**KIRKLEES METROPOLITAN COUNCIL
INVESTMENT & REGENERATION SERVICE**

DELEGATED DECISION TO DETERMINE PLANNING APPLICATIONS

Reference No:	2023/62/93715/W
Site Address:	Waverley United Reformed Church, Waverley Road, Huddersfield, HD1 5NA
Description:	Alterations to and change of use of teaching institute (use class F1) to form 10 apartments (use class C3) with associated external works including formation of car parking (within a Conservation Area)
Recommending Officer:	William Simcock

Officer Report – 2023/93715

Project Name Waverley Church, Waverley Road, Huddersfield, HD1 5NA	
Drawing Title: Option 4-Proposed Elevations	
Drawing Number: TR-A23-0802-006	Scale: 1 : 100@A1
Date: 23/07/24	Revision: G
Drawn By: AM	Checked by: JA
Reason For Issue: Planning

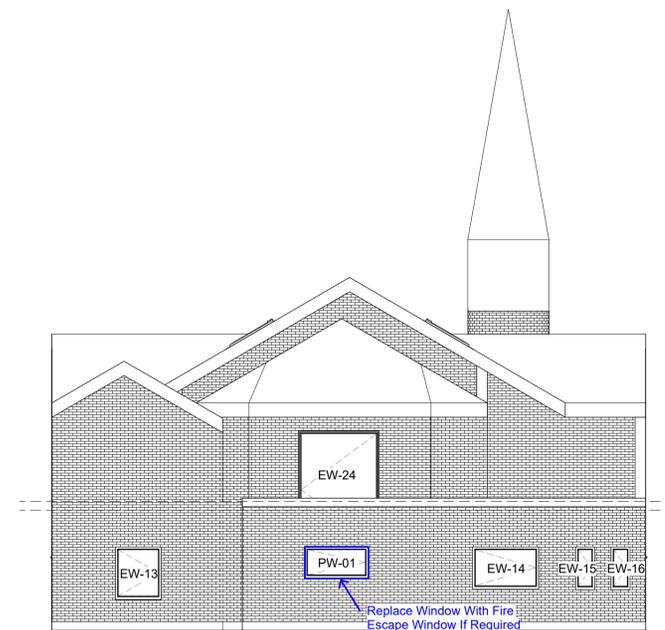
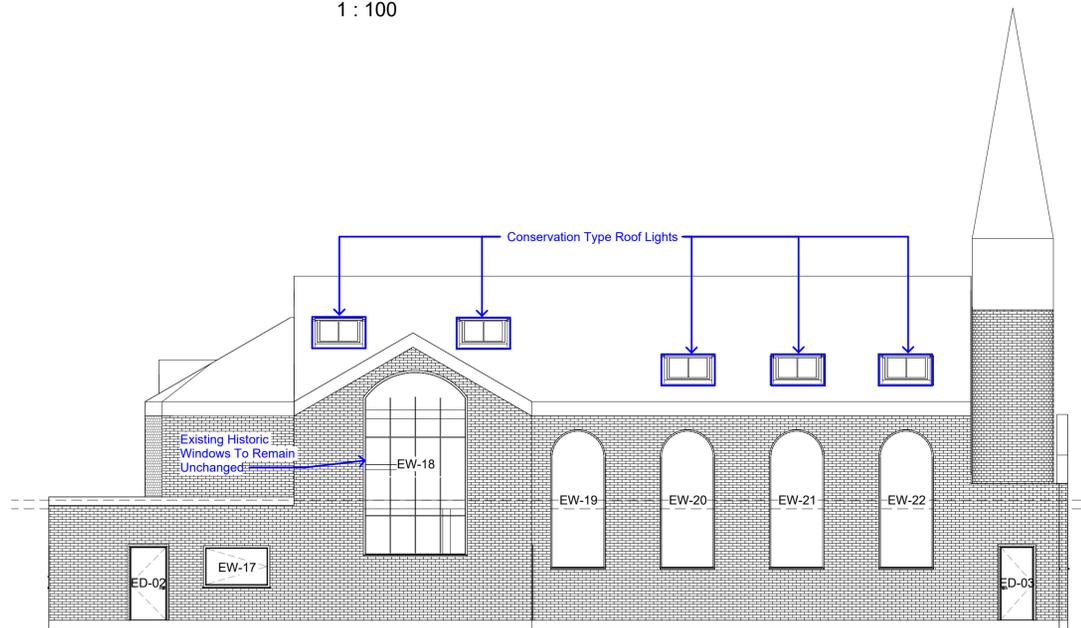
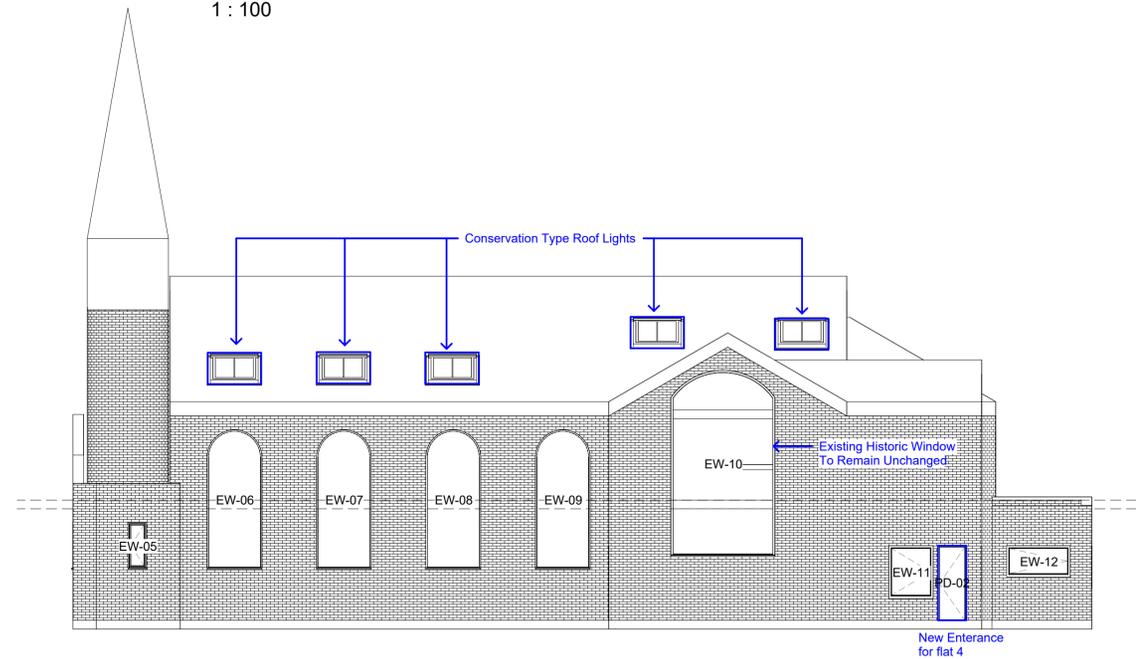
The only external alterations to the existing building would be to doors and windows comprising new entrance doors, the replacement of glass in existing frames, and the addition of ten roof lights (reduced from 12).

Officers expressed concerns early in the process about the lack of clarity concerning the windows, in that the drawings did not show the stone tracery or make it clear how much of the original glazing was to be retained. Furthermore, it was unclear how the new doors in the eastern and western elevations would be formed since the drawings showed the wall either side of the large arched window as flat when in fact it is stepped.

The applicant proposes to replace window PW01, a three-light mullioned window in the southern elevation, with a fire escape window, for which it is recommended it be conditioned that details be submitted for approval.

Leaded glazing is an important contributing feature to the character of the building and needs to be retained. The applicant's agent was advised that the rectangular panes could be replaced (with clear glazing if deemed necessary) and leaded in, but the patterned border glazing should be retained. The revised proposed elevation drawing TR-A23-0802-006 rev G includes the annotation 'All existing windows to remain but glass changed to clear'. Some windows are shown as obscured glass (including windows PW01 ND ew14). For clarity, a condition should be applied requiring details of all replacement glazing and windows, to be submitted for approval prior to window alterations being carried out, notwithstanding the details on the approved plans.

Amended drawings have been submitted to show the doorways to flats 2 and 3 omitted from the side gables. These are now in more sensitive locations (in the north wall) where there would be minimal impact on the architectural detailing. A condition should, however, be applied requiring 1:20 elevations and 1:5 sections of the proposed new external doors to be submitted for approval, to include the design and materials, door surround detailing, and depth within the reveals.

In response, amended and additional plans including a window schedule with photographs and brief descriptions were submitted. The window schedule is cross-referenced to the revised proposed elevation TR-A23-0802-006 rev G and floor plans TR-A23-0802-005 rev G.

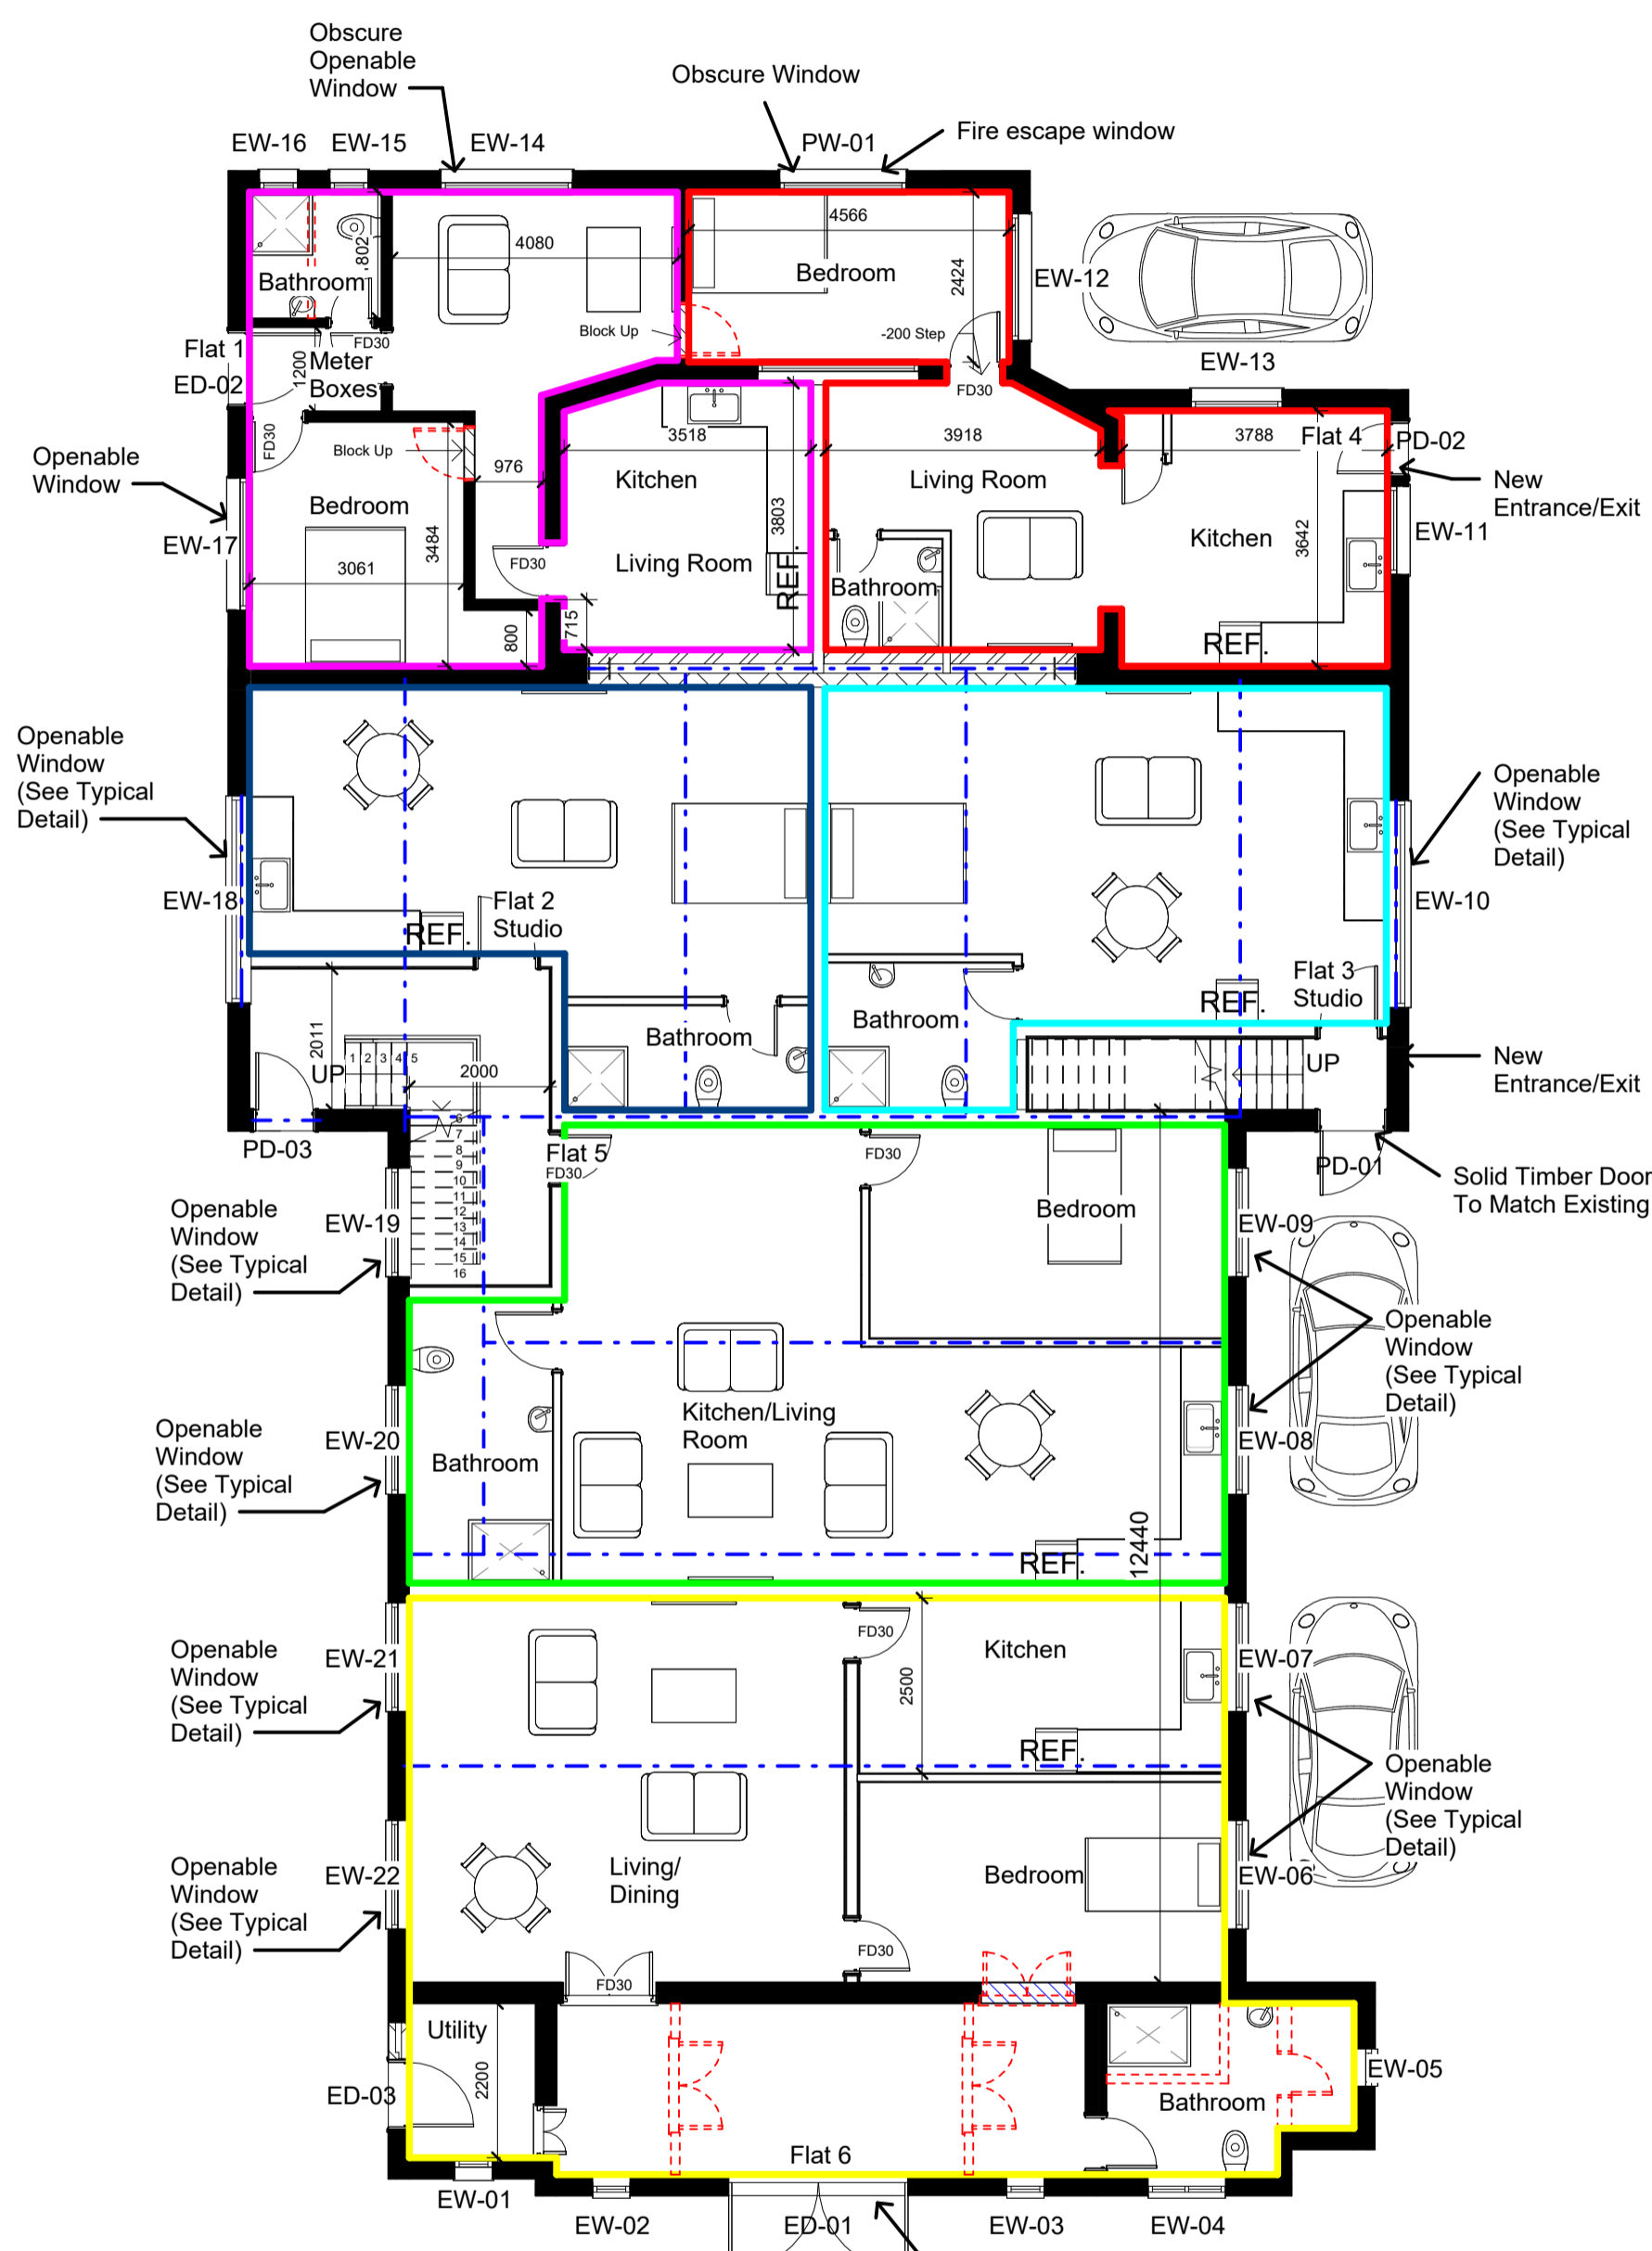
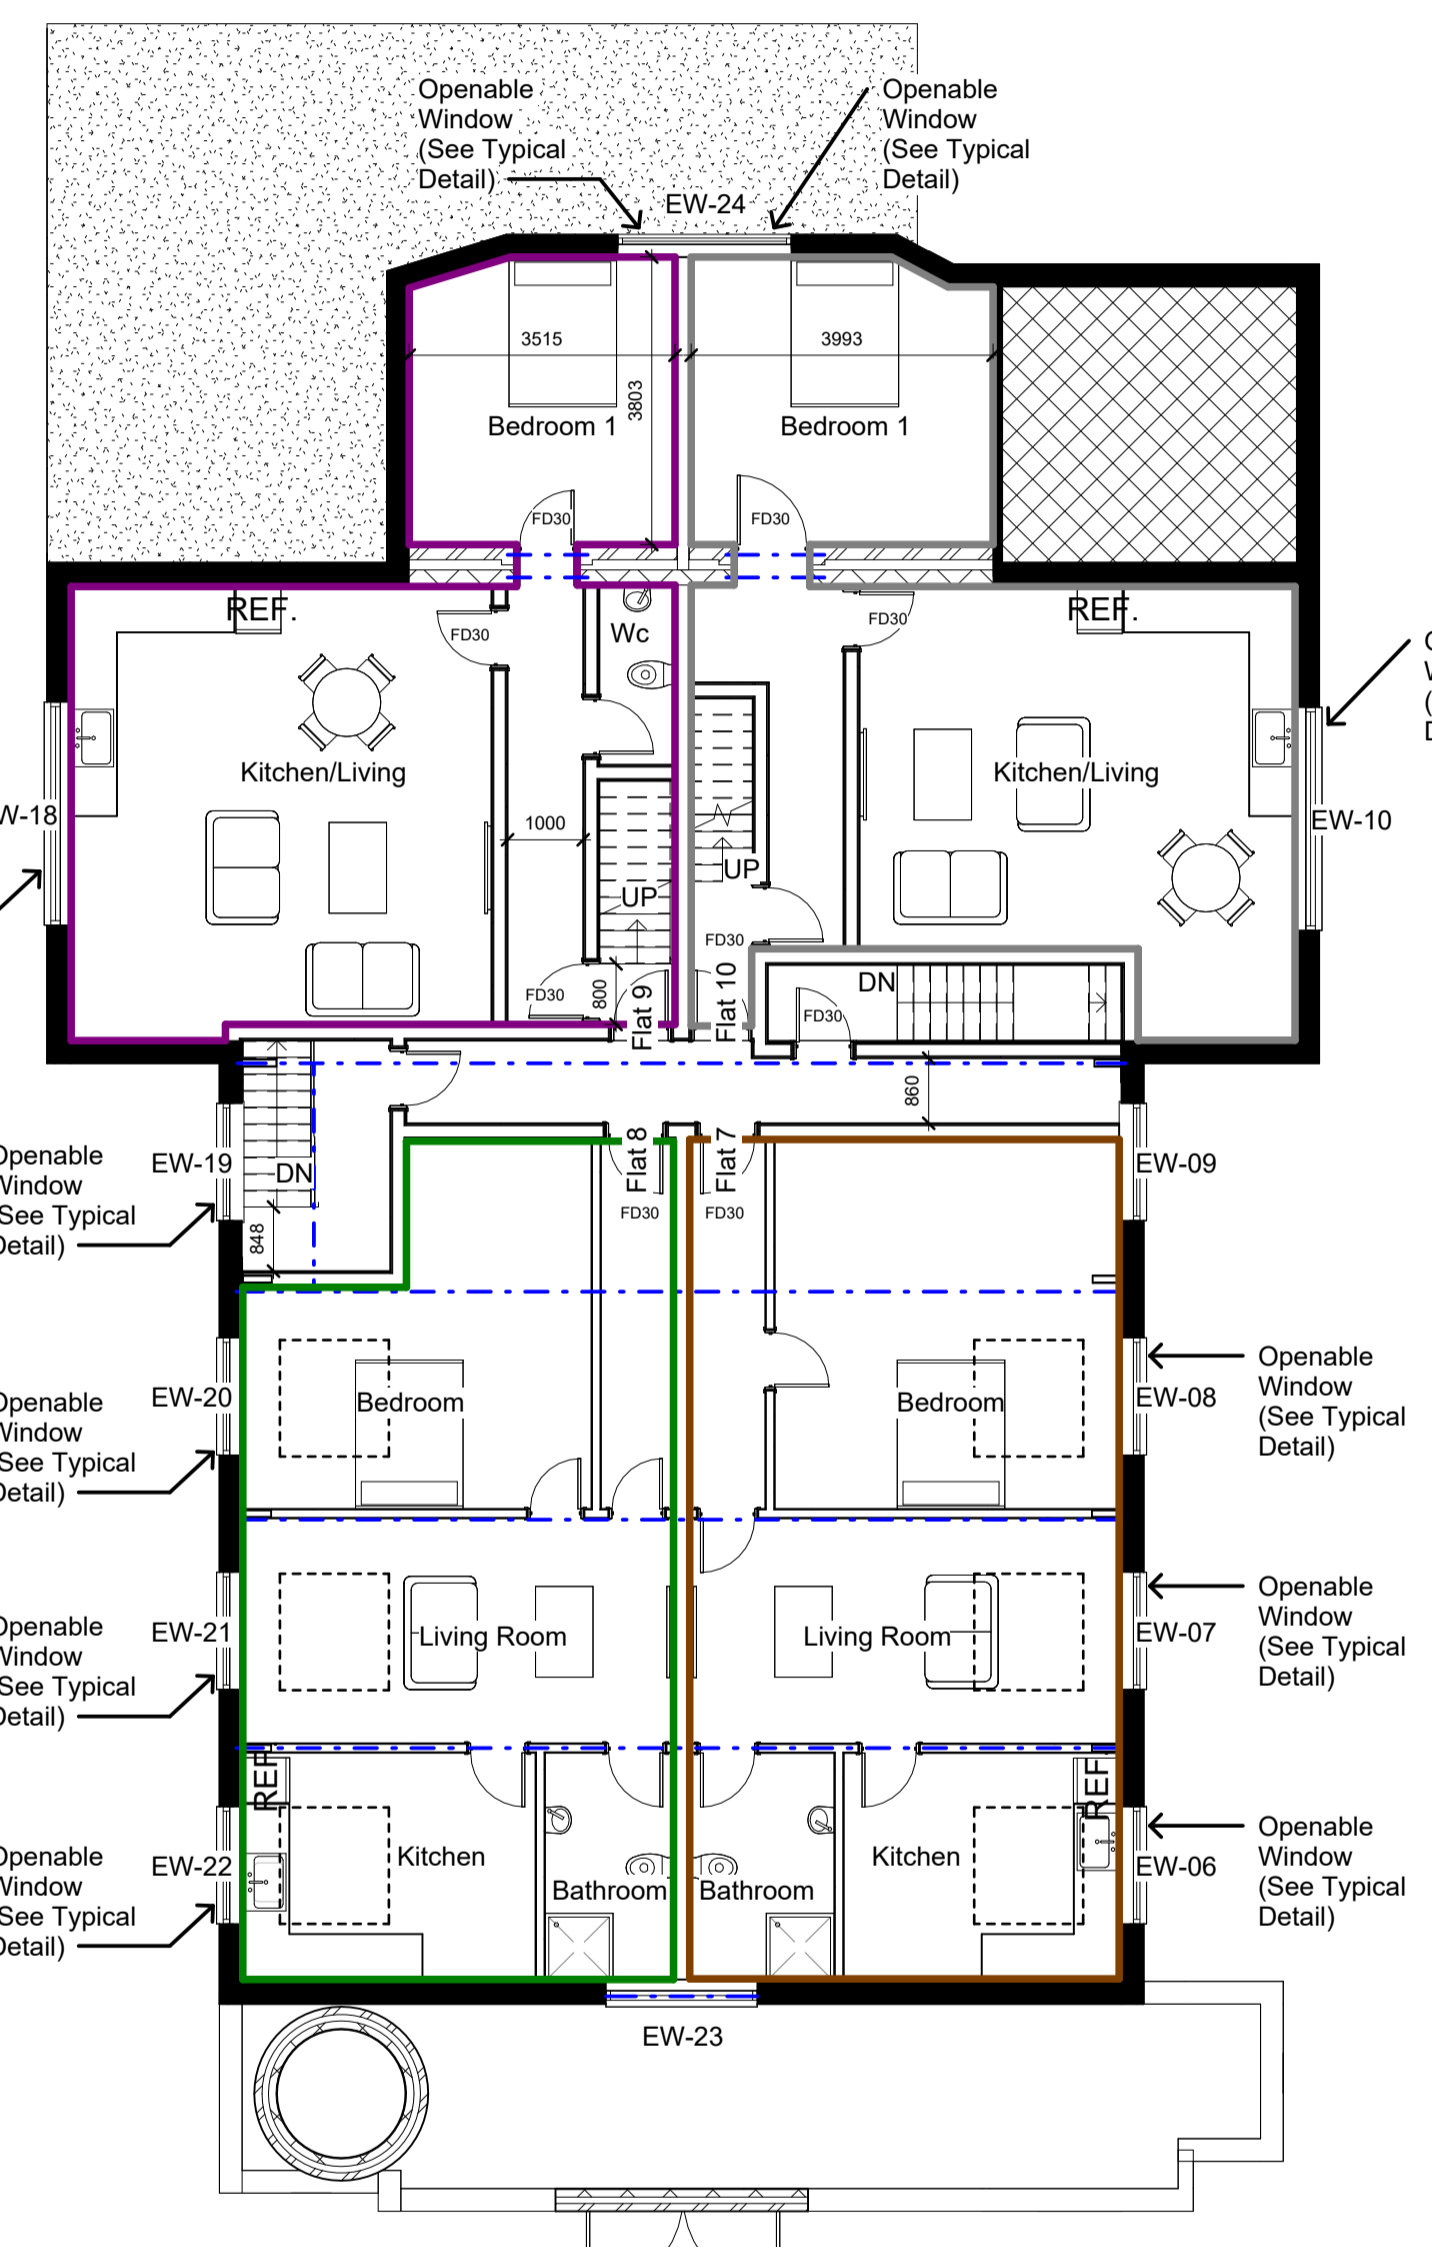
It is unclear from the submitted documents how fire protection and noise transmission would be addressed at first floor level without harming the character of the tall windows (both the smaller side windows with tracery and the larger side gable windows). A condition should be applied requiring

As originally submitted, one dwelling would have been of sub-standard floorspace. In the plans now under consideration, following the reduction in the number of units and rearrangement of internal floorspace, all apartments would meet or exceed the NDSS standards. The smallest single-bedroom apartment, Flat 4, would provide 40sqm of floorspace, which is 3sqm in excess of the recommended minimum. The 2-bed maisonettes would provide 80sqm, as against the minimum standard which is 70sqm.

Flats 1 and 2 would have their windows (bedroom, and combined living accommodation for studio flat 2) only just over 2m from the eastern site boundary. Such a situation would normally be deemed unsatisfactory from the point of view of outlook and privacy, but it is noted that the floor levels in the building, which are higher than natural ground levels on the western side, would ensure that the windows would be well above the level of the boundary fence and would therefore not have their light or outlook obstructed. Moreover, the building on the adjacent site is not in residential use and it is considered that its users would not suffer from being overlooked. Whilst the privacy of future occupiers might be somewhat compromised as a result, future residents would be aware of this and it is on balance judged acceptable.

The bedroom windows in Flats 5 and 6 would have a car parked adjacent to them. Similar arrangements are normally discouraged as they affect the outlook for future residents. In this instance it is considered that there is no realistic alternative, given the limited space within the curtilage of the building, and can be accepted.
